NSW RURAL FIRE SERVICE

Your reference: MP 08_00167 (Mod 3)
Our reference: S08/0040
DA17020305918 PC

9 May 2017

MP 08_0167 (Mod 3) – Belle O'Connor Street, South West Rocks

Figure 4 – Proposed Seniors Living Development Concept – Updated in Rev A

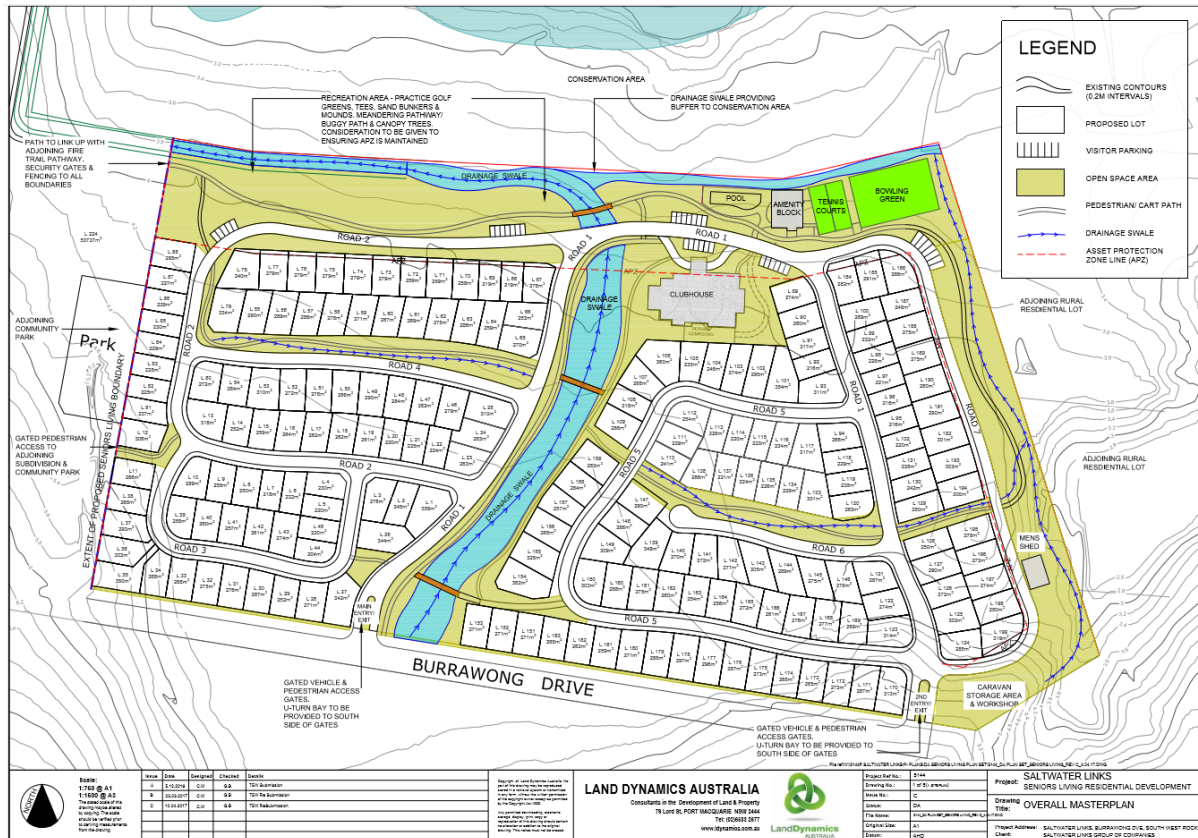
1. At the commencement of construction and in perpetuity the entire site shall be managed as an inner protection area as outlined within section 4.1.3 and Appendix 5 of 'Planning for Bush Fire Protection 2006' and the NSW Rural Fire Service's document 'Standards for asset protection zones'.
2. A Bush Fire Management Plan is to be prepared for the open space areas and asset protection zones shown on the plan titled 'Overall Masterplan' prepared by Land Dynamics Australia (Ref: 5144, Issue C, dated

3. A restriction to land use pursuant to section 88B of the 'Conveyancing Act 1919' shall be placed on the following areas of Lot 2 DP 1220275 (as amended) for the purpose of a temporary asset protection zone:
 - i. for a distance of 22 metres to the west of Lots 11, 12, 35-38 and 81-86; and
 - ii. for a distance of 50 metres to the north-west of Lot 88.

Stage 1 – Lots 9 to 14
Stage 2 – Lots 27 to 40 and Club House
Stage 3 – Lots 54 to 66
Stage 4 – Lots 67 to 88
Stage 5 – Lots 89 to 100
Stage 6 – Lots 101 to 107
Stage 7 – Lots 118 to 132 and 170
Stage 8 – n/a
Stage 9 – Lots 151 to 153
Stage 10 – Lots 171 to 183
Stage 11 – Lots 184 to 192
Stage 12 – Lots 193 to 199
